Recommendation: Refusal

Proposal: Single storey extension to rear, removal of existing conservatory and lean-to

North Elevation 1:50

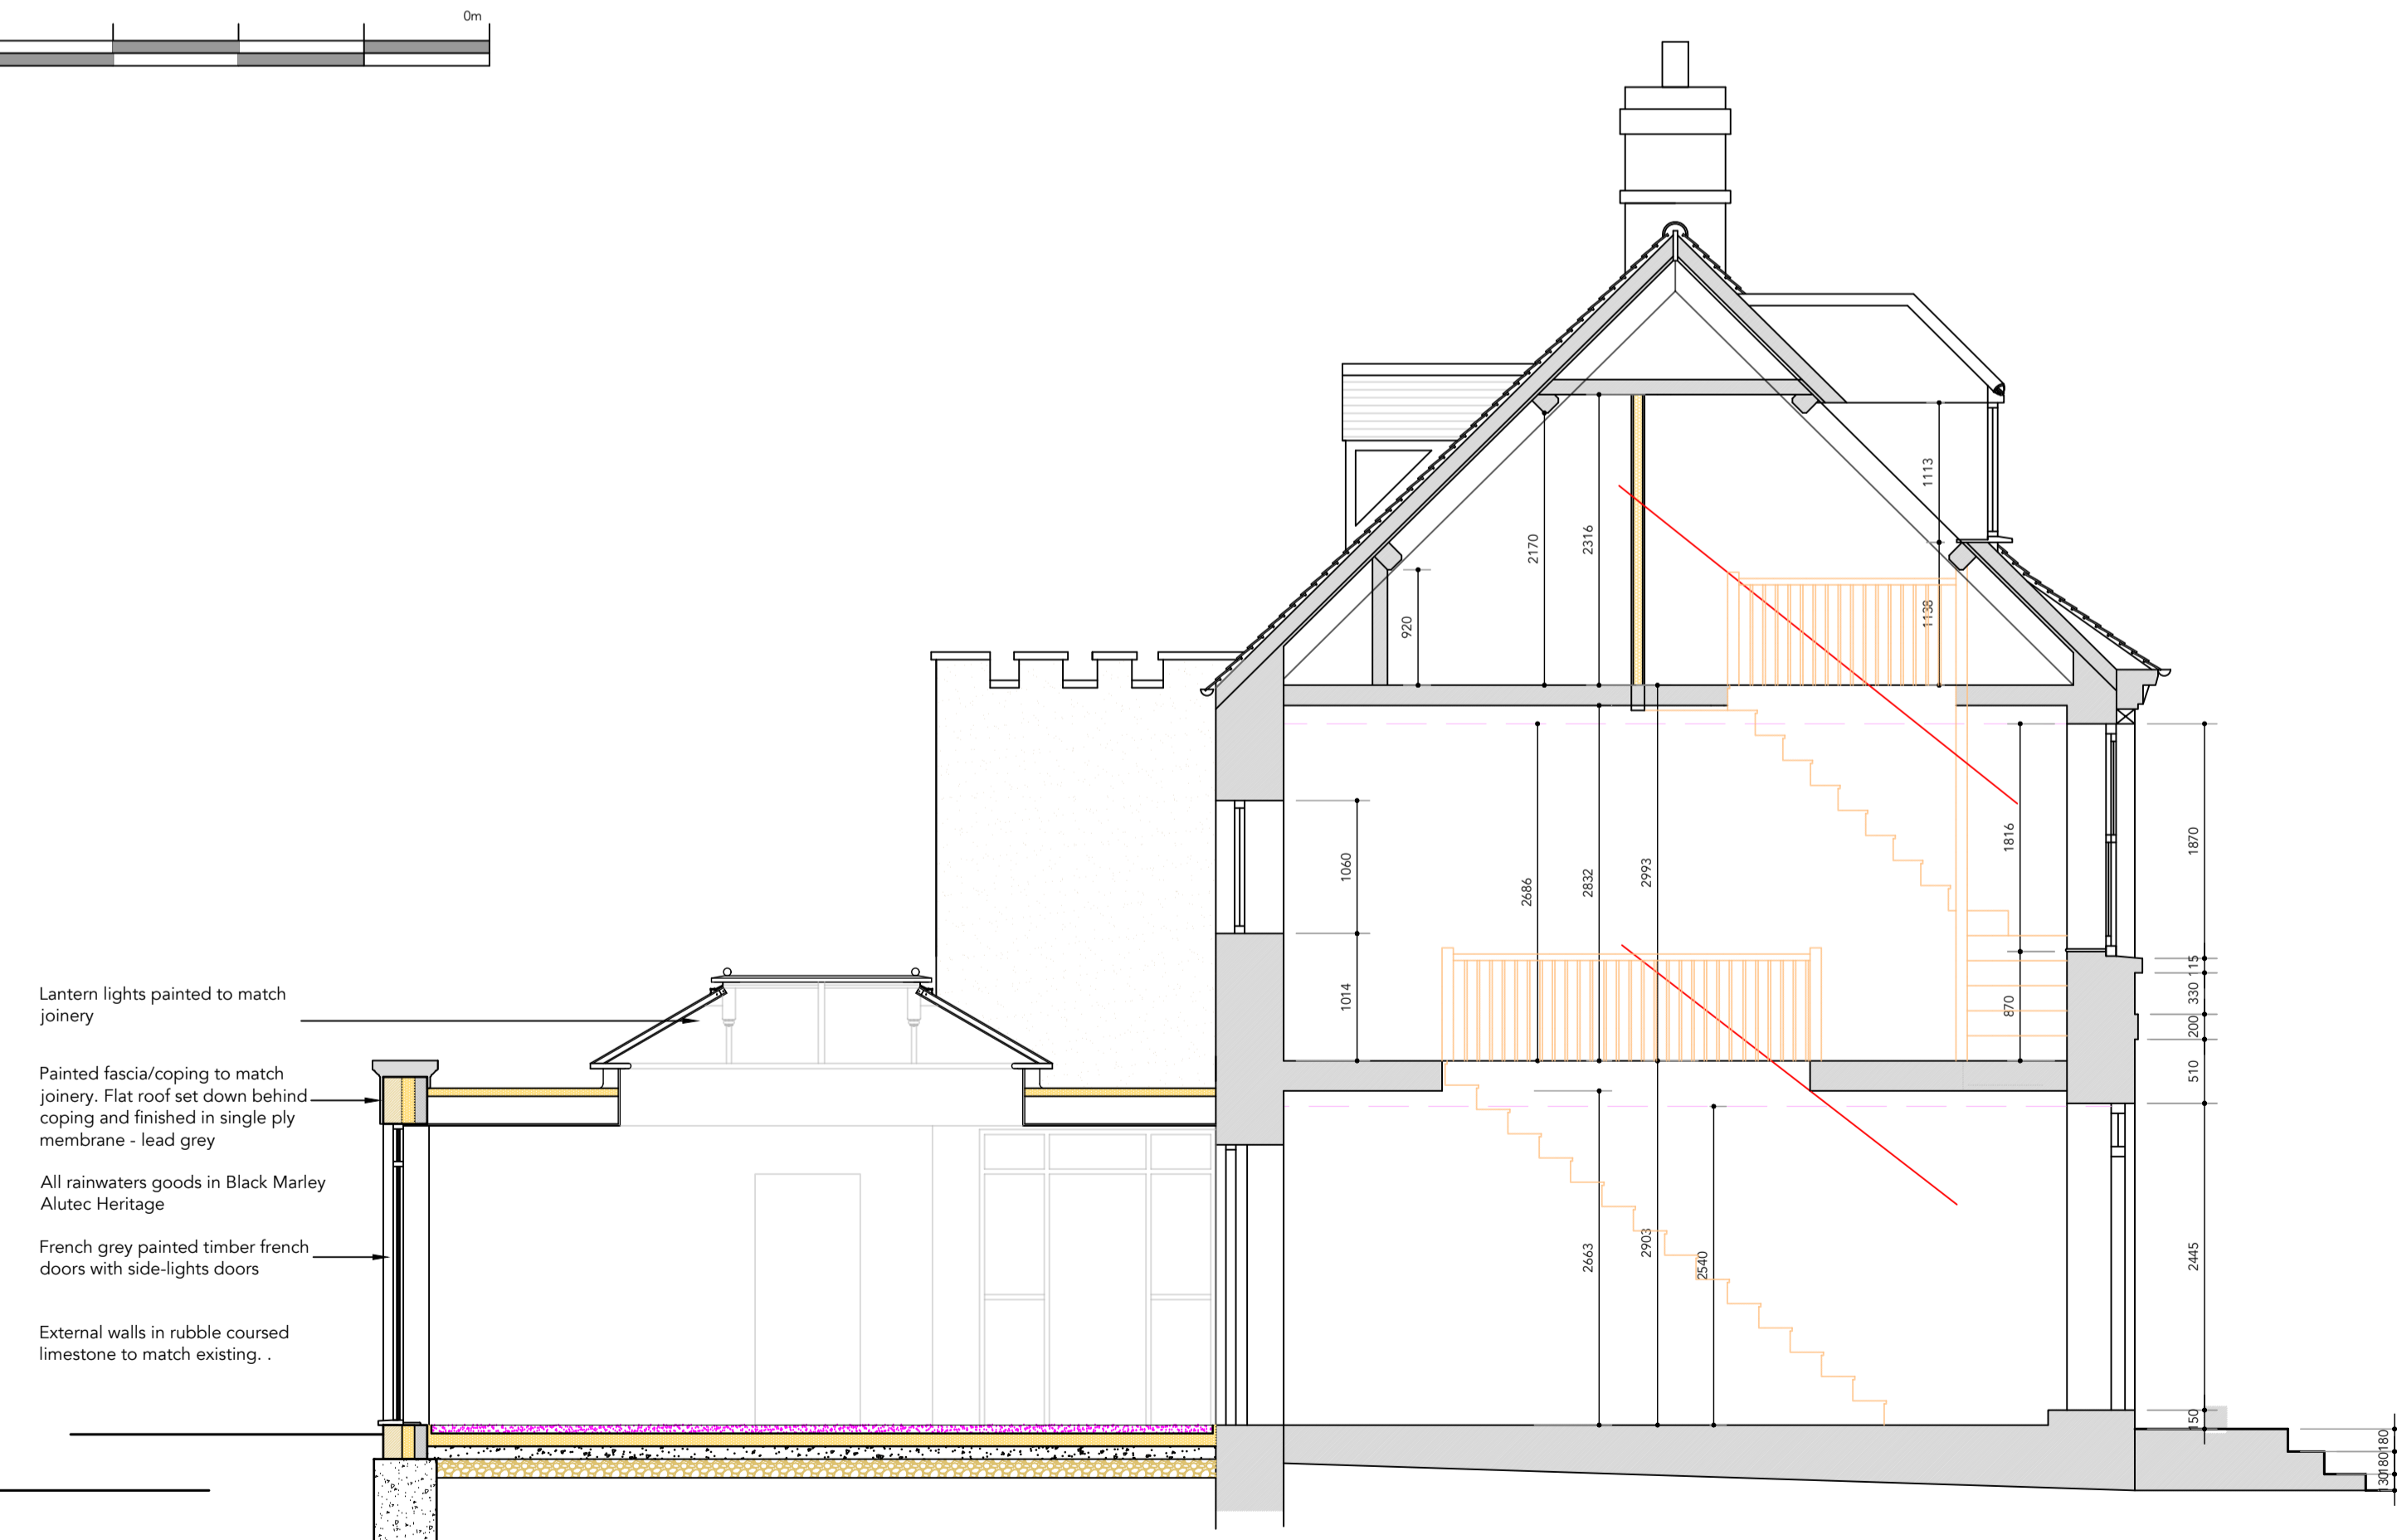
- 8.5. The proposed extension would be visible from the public realm, Church Lane. The proposed development would be of an overbearing and detracting design and style to the existing dwelling, which in this circumstance is unacceptable due to its scale, siting and appearance would adversely impact the character and appearance of the listed building.

- 8.6. The proposal is not a characteristic or an expected feature of buildings of this type and age and would result in a development that would dominate and detract from the main historic part of the dwelling, preventing the legibility of the development of the main dwelling. The proposal would obscure a significant portion of the rear elevation of this Grade II listed building. The current proposal is for an extension which would protrude from the host dwelling by an additional 1.6 metres. The protrusion of the extension beyond the rear wall of the existing parts of the building would contribute to the over-dominance of the proposed extension. The proposed extension would be neither minor nor sympathetic and would have a detrimental effect on the character and appearance of the listed building.

- 8.7. The proposed windows and doors to be included would be grey timber. While it is acknowledged that the windows and doors would be situated to the rear of the development (on the north elevation), they do not match the existing windows and doors. The proposed windows and doors have already been discharged as acceptable under the 2018 DISC applications. These additions within the proposed development are considered acceptable in this regard.

- 8.8. Having regard to its scale, siting, design and appearance, the proposed extension is not considered to be acceptable due to its overbearing and dominating size and scale of development. It would be out of keeping with the form and character of the host building.
